Colham Manor Primary School
Violet Avenue
Hillingdon
Middlesex
UB3 3PT

Ref: 8721/APP/2013/1508

Re: Planning application at: Colham Manor Primary School, Violet Avenue

Drawing Title
Proposed Plan

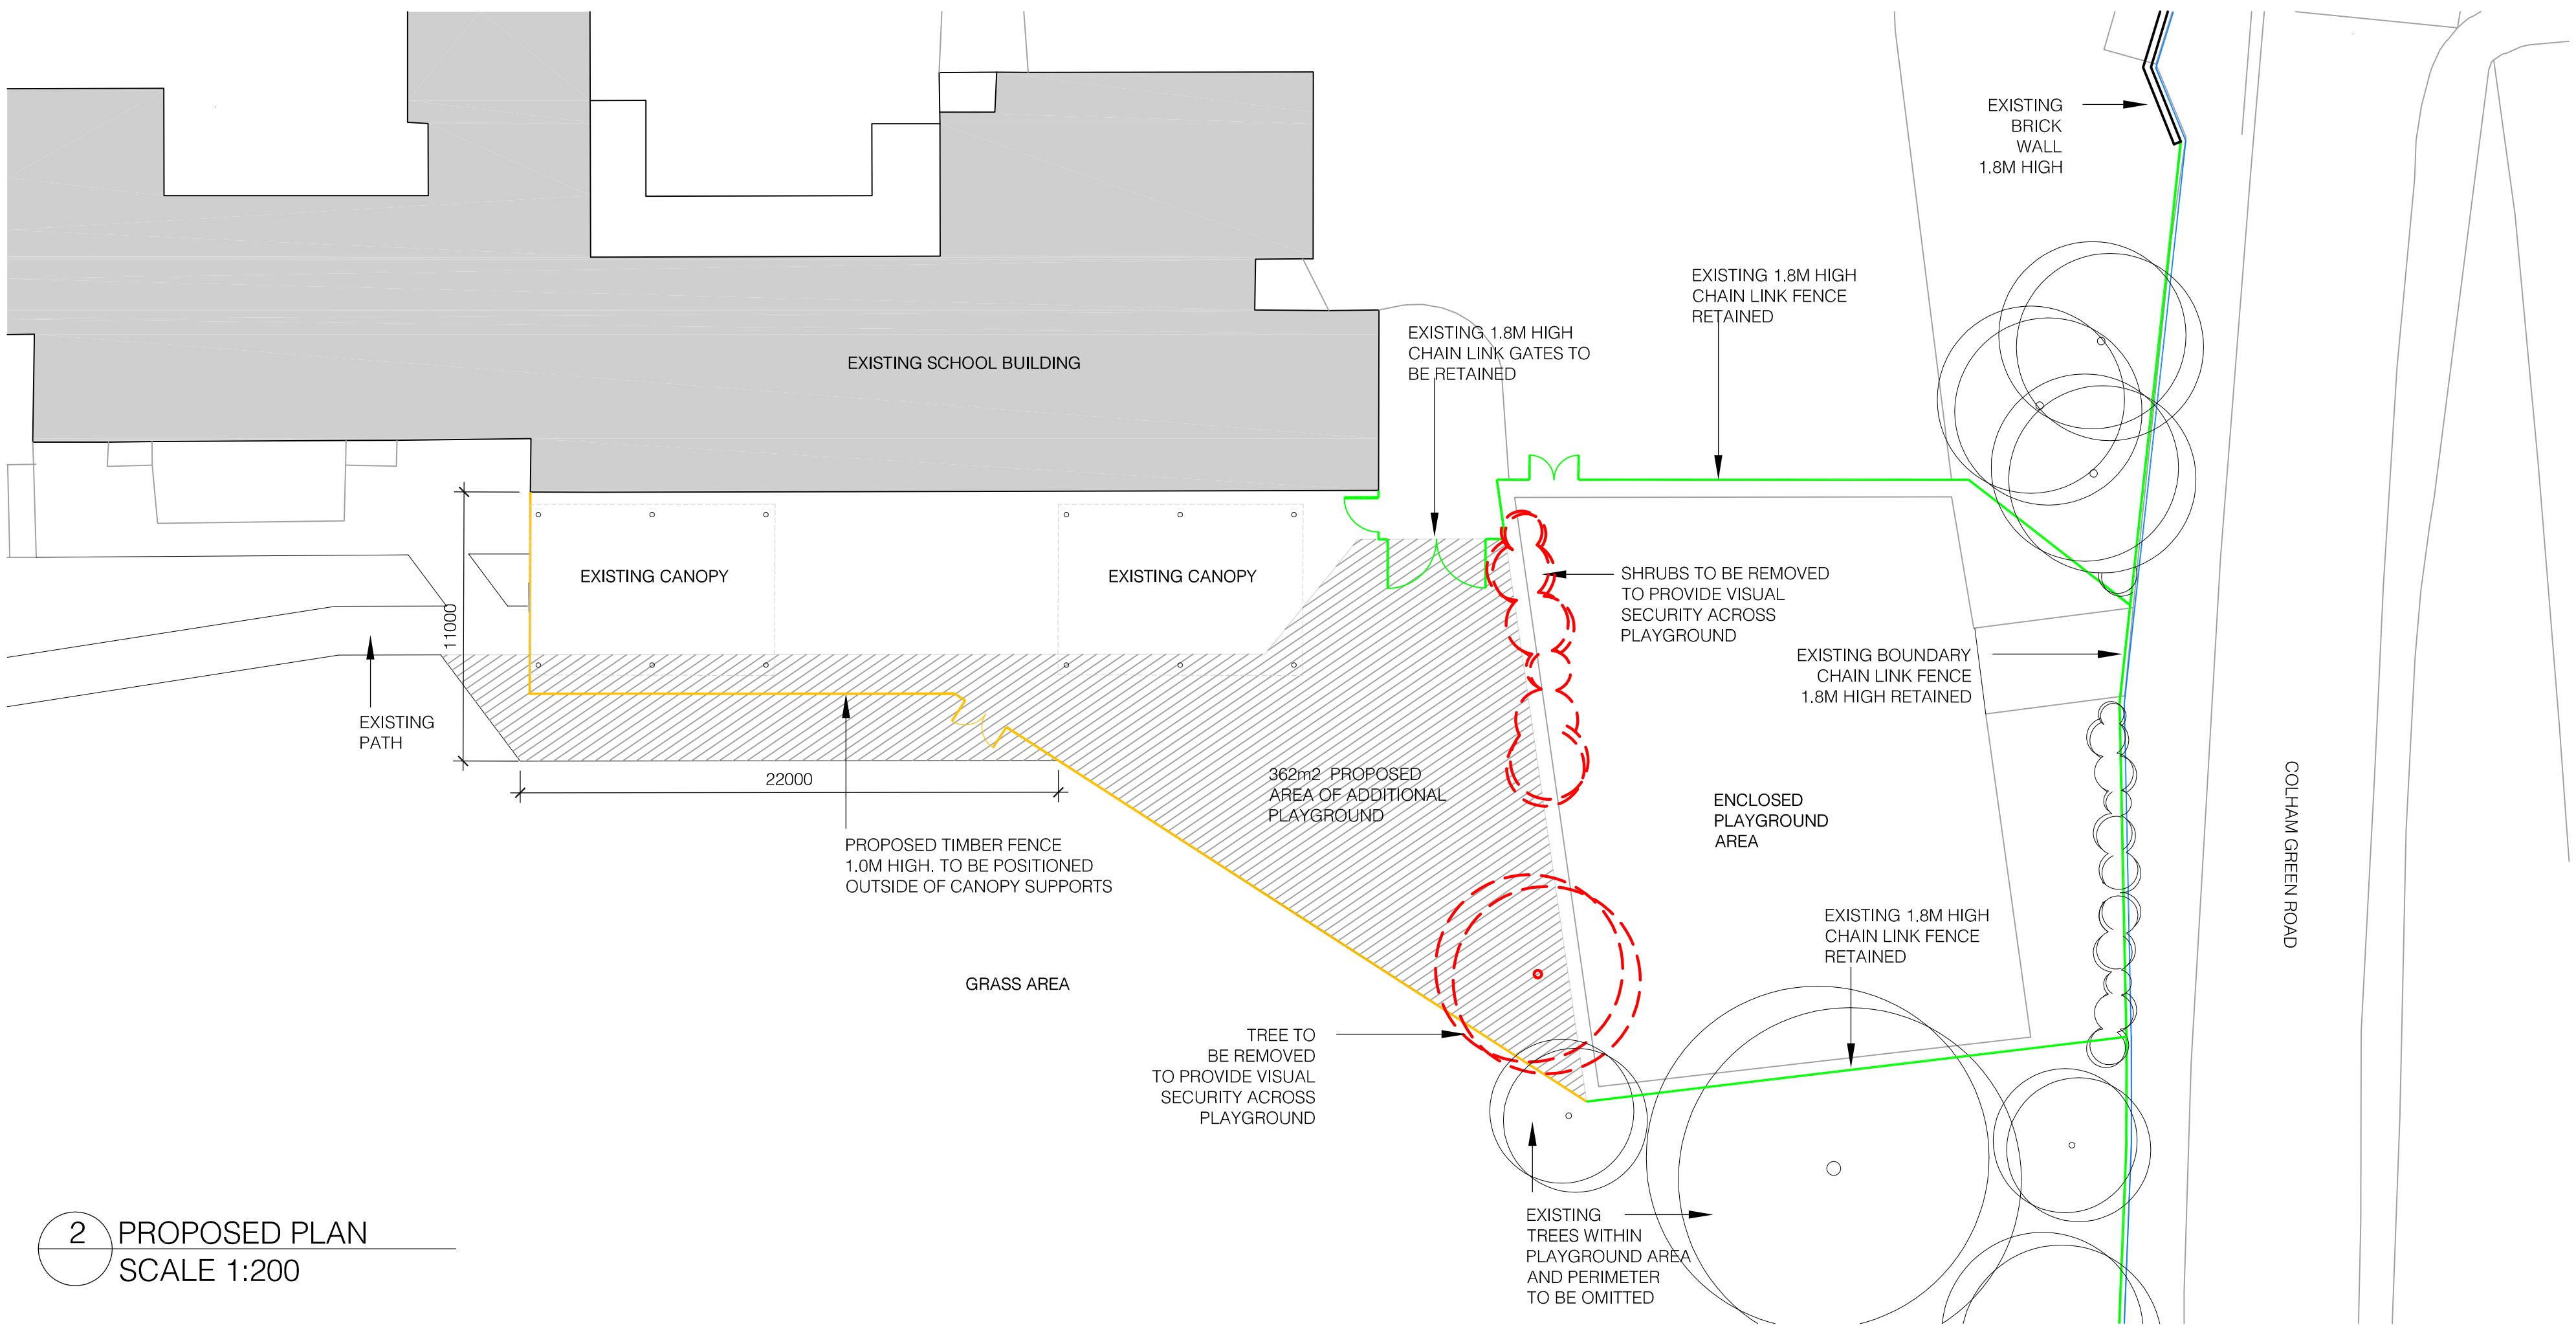
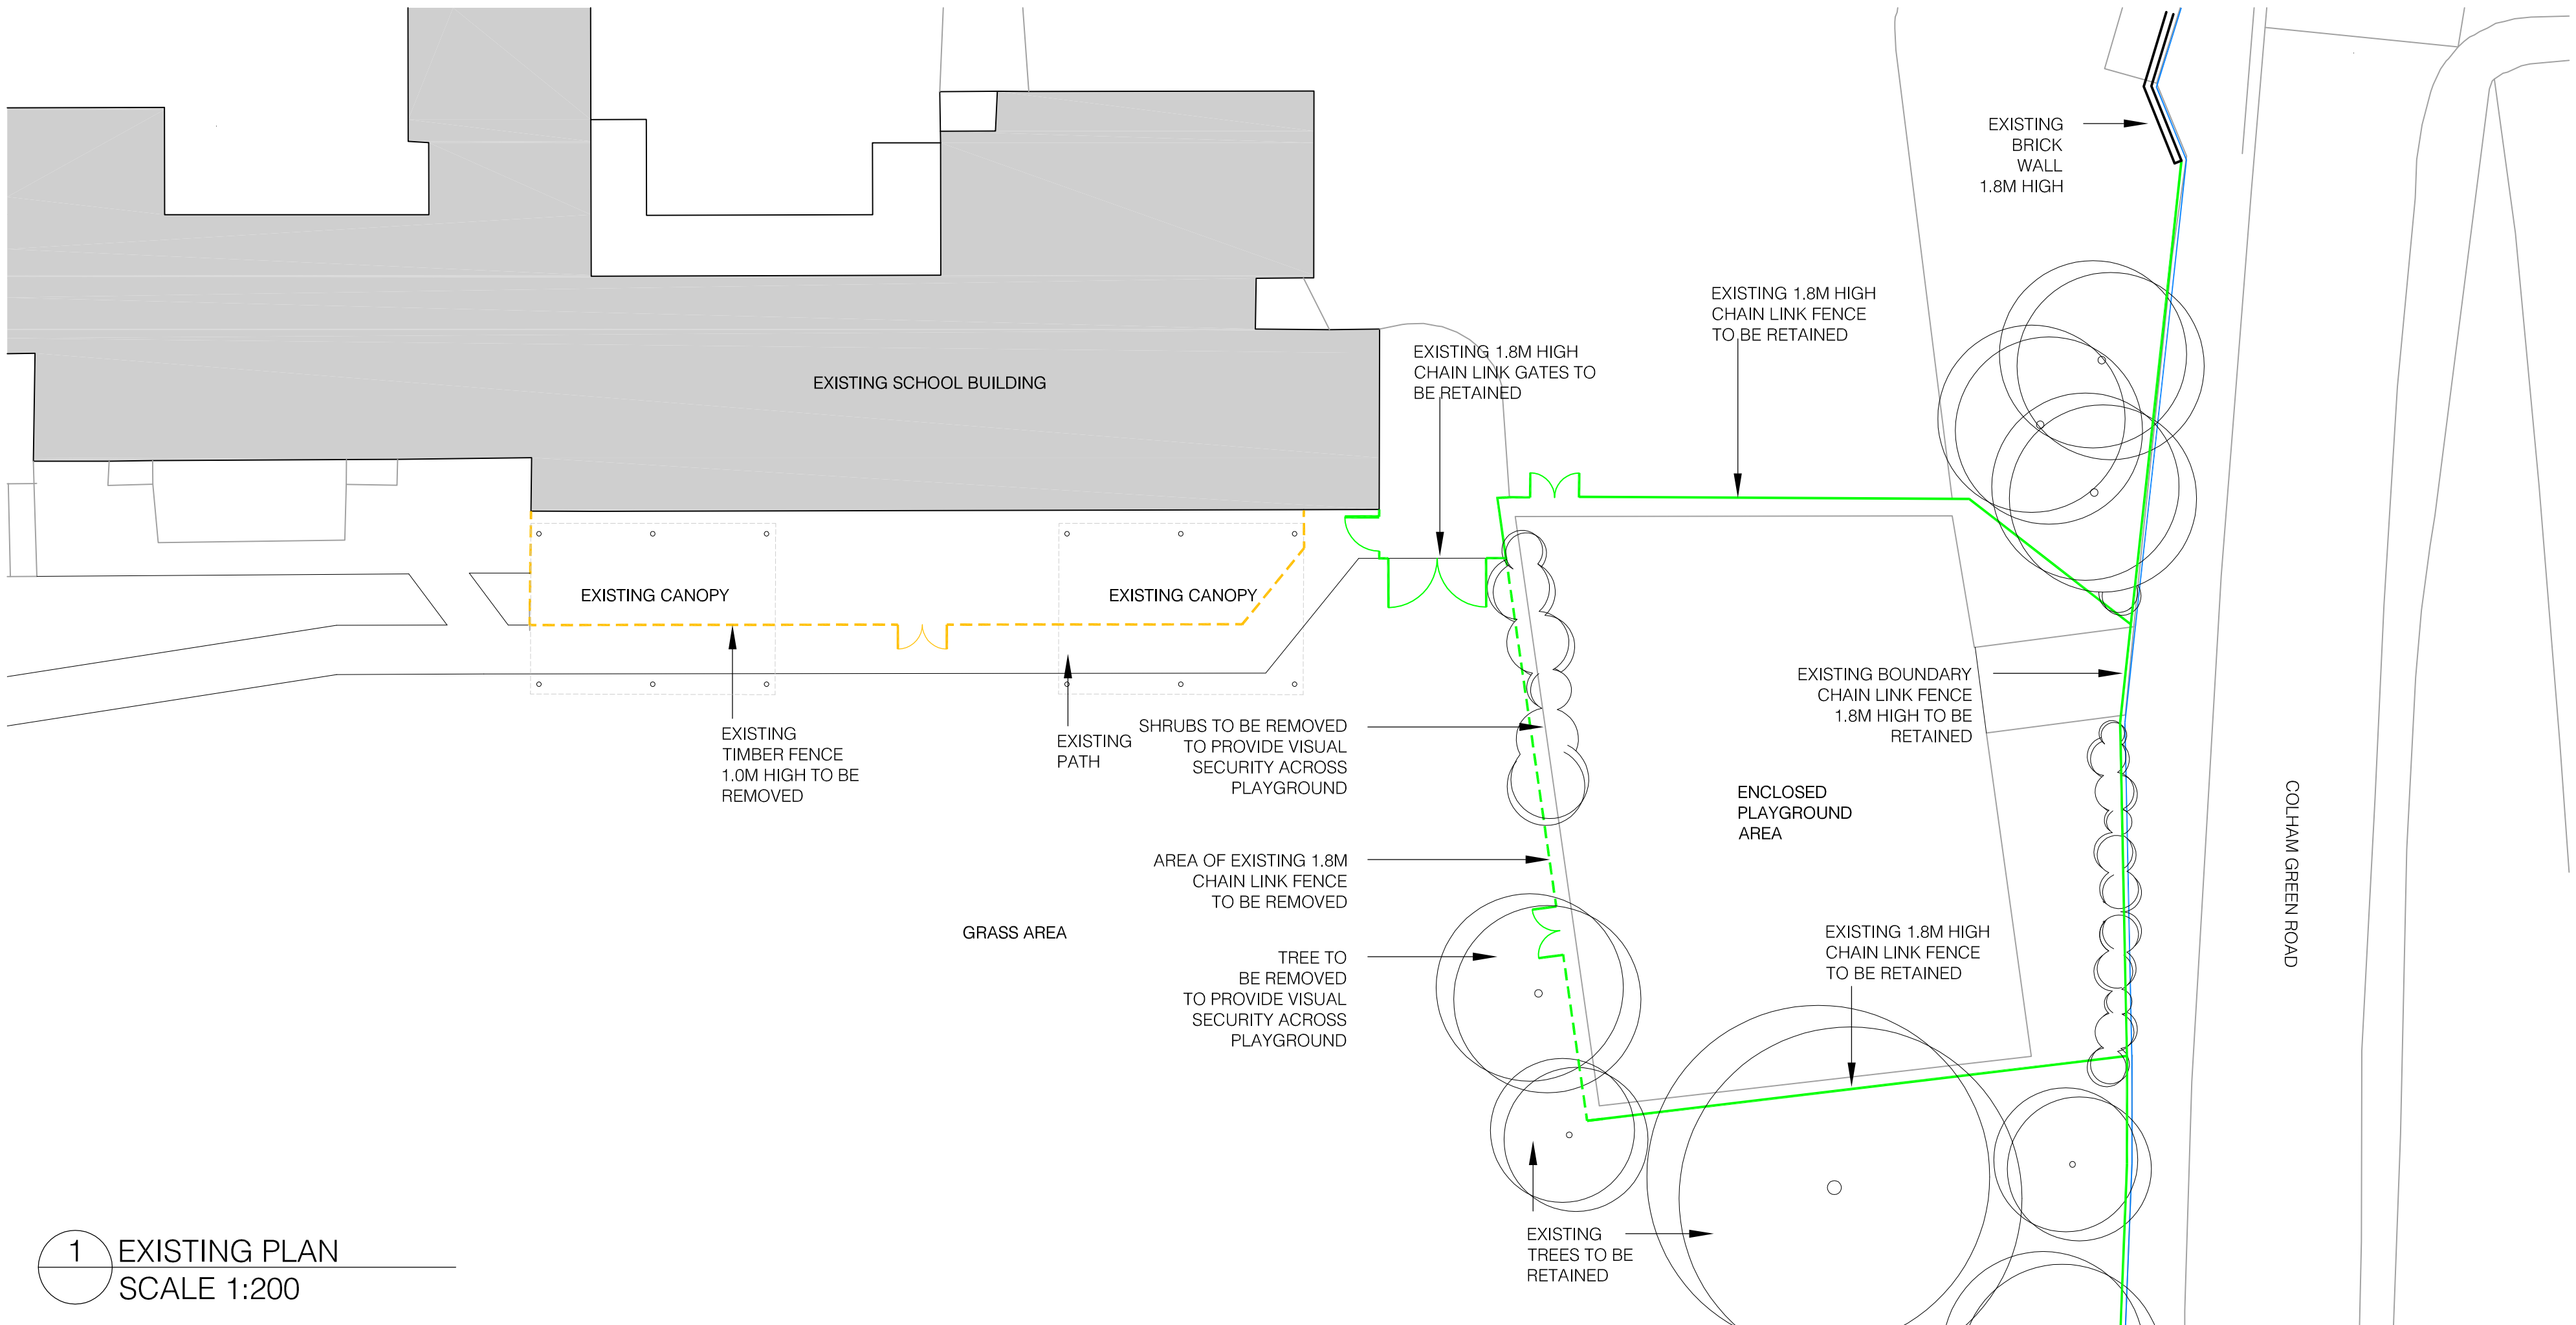
- 2. Scale Labels Required: Please annotate the scales to which each drawing has been drawn to (e.g. 1:50, 1:100 etc.);
- 3. Plan Labels Required: It is not clear on the submitted plans which area is which (i.e. which is parking and which is the extended playground.) Please label the areas accordingly to clarify the situation;

- 4. Parking Layout Required: Please demonstrate the proposed parking layout on the plans;
- 5. Certificate of Ownership Required: You are required to complete one of the Certificates of Ownership on the application form. Please sign either certificate A, B, C, or D accordingly. Please find enclosed a blank copy of the forms for you to complete;

Drawing Title
Location Plan

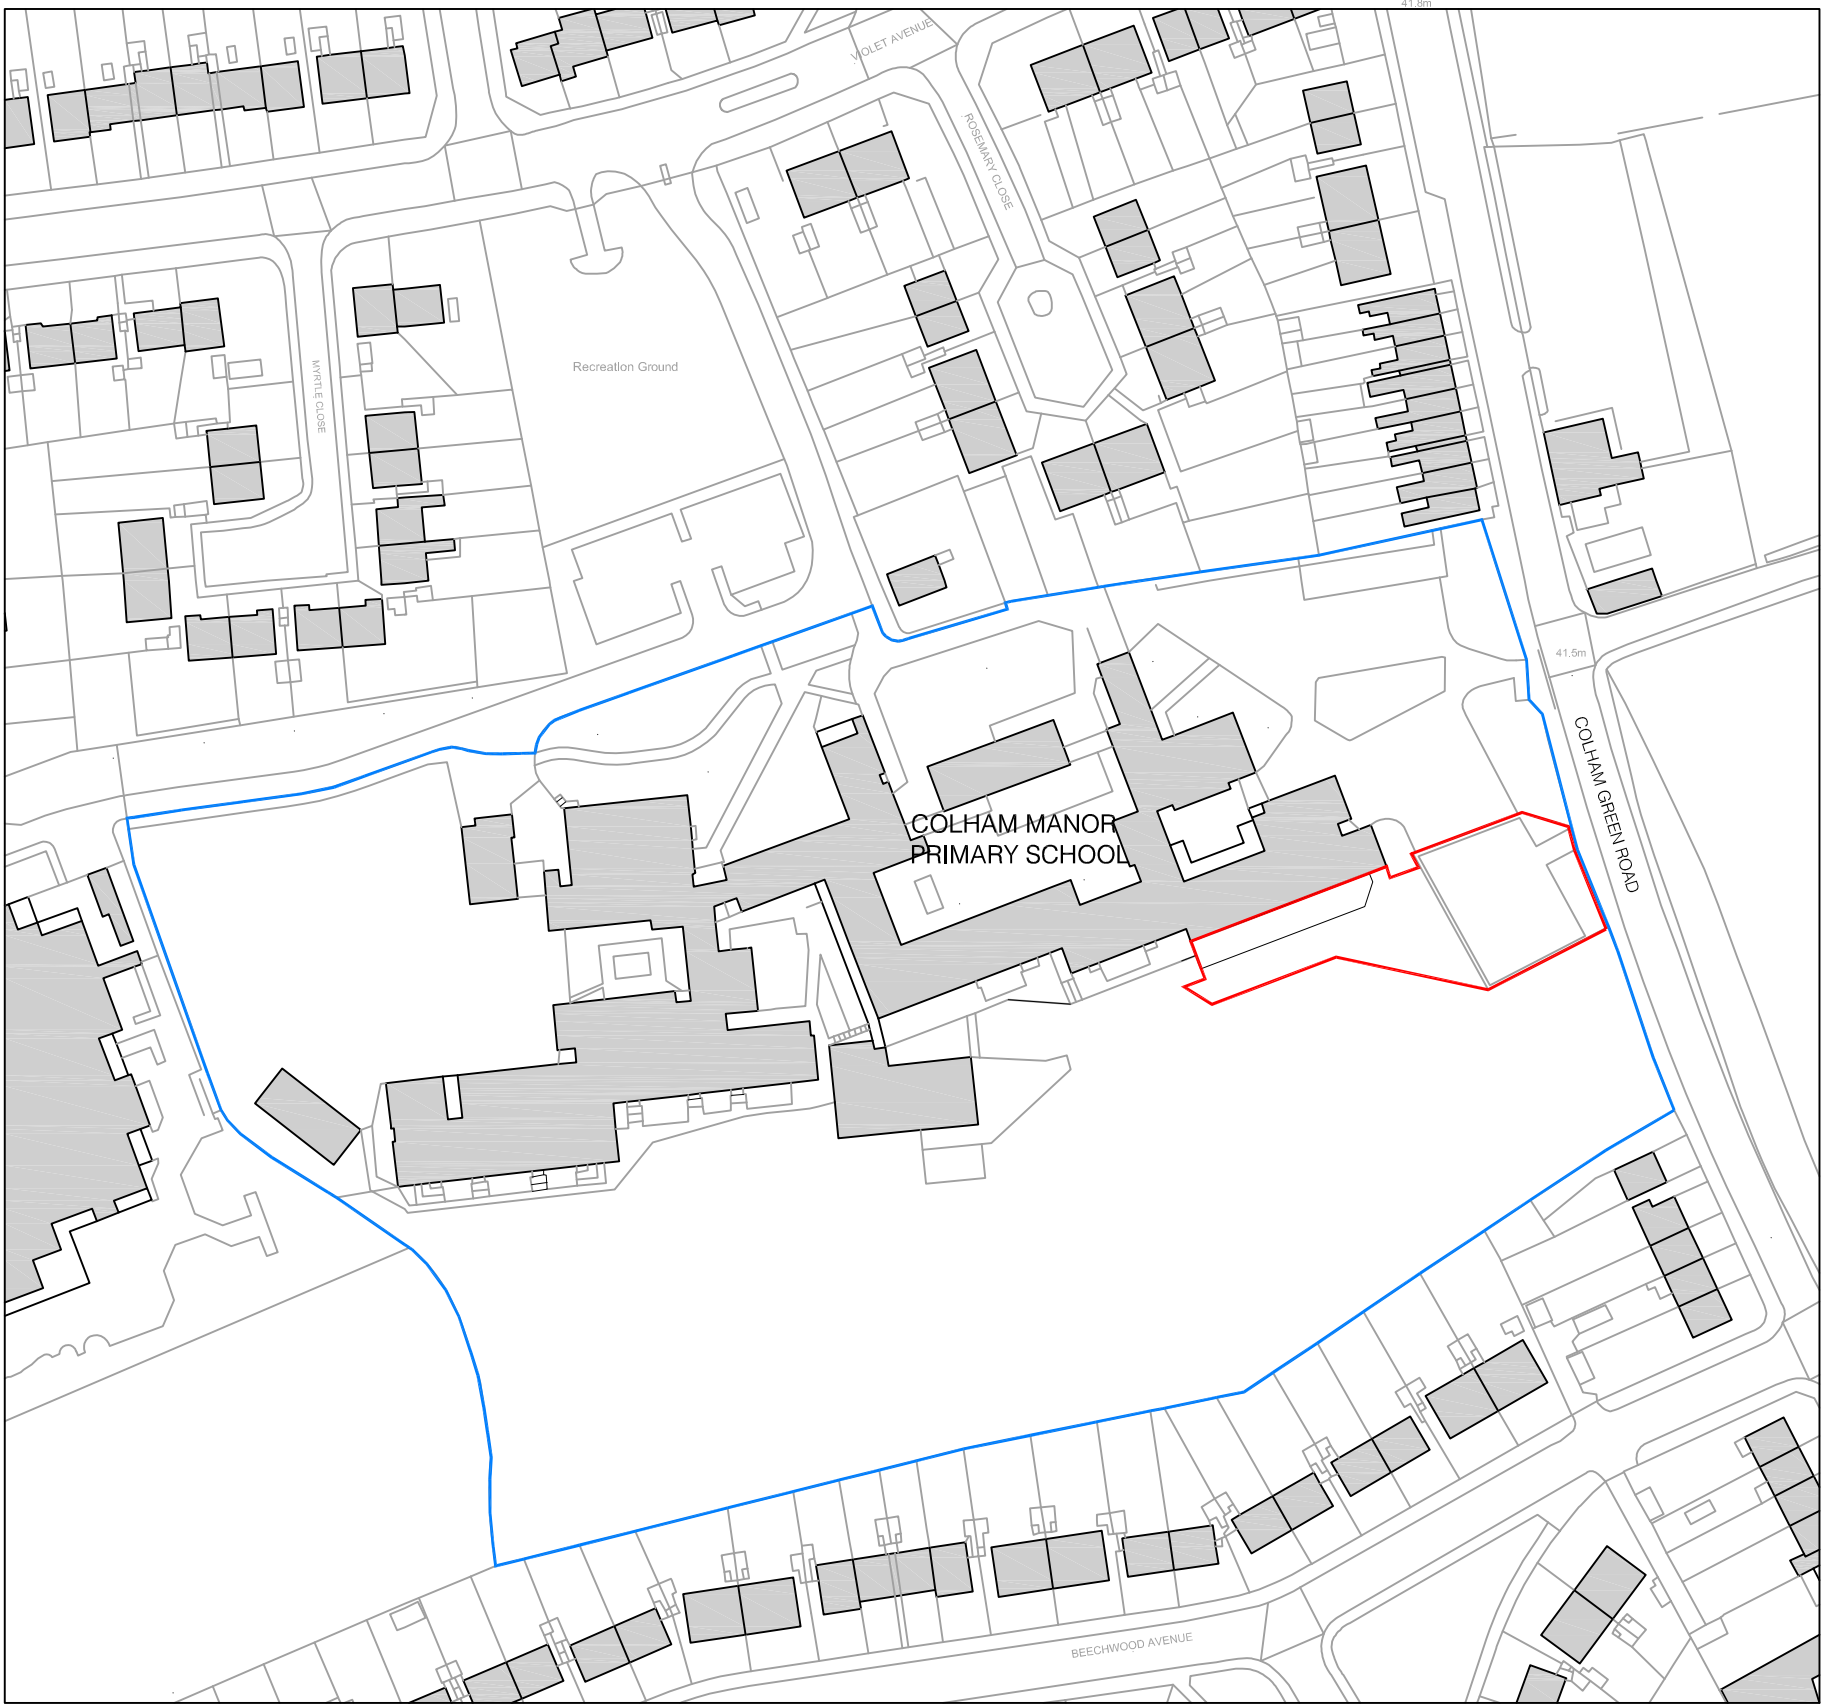
- 1. Location Plan Required: Please submit an up to date location plan. This plan should be an ordnance survey type plan at an identified standard metric scale, typically 1:1250 or 1:2500. The plan should show the site to which the application relates outlined clearly in red and should identify sufficient surrounding roads with an arrow showing the direction of north to illustrate the location. If you require assistance obtaining a location plan then you can visit Boville & Wright, High Street, Uxbridge, (Opposite Tesco Store) 01895-450321;
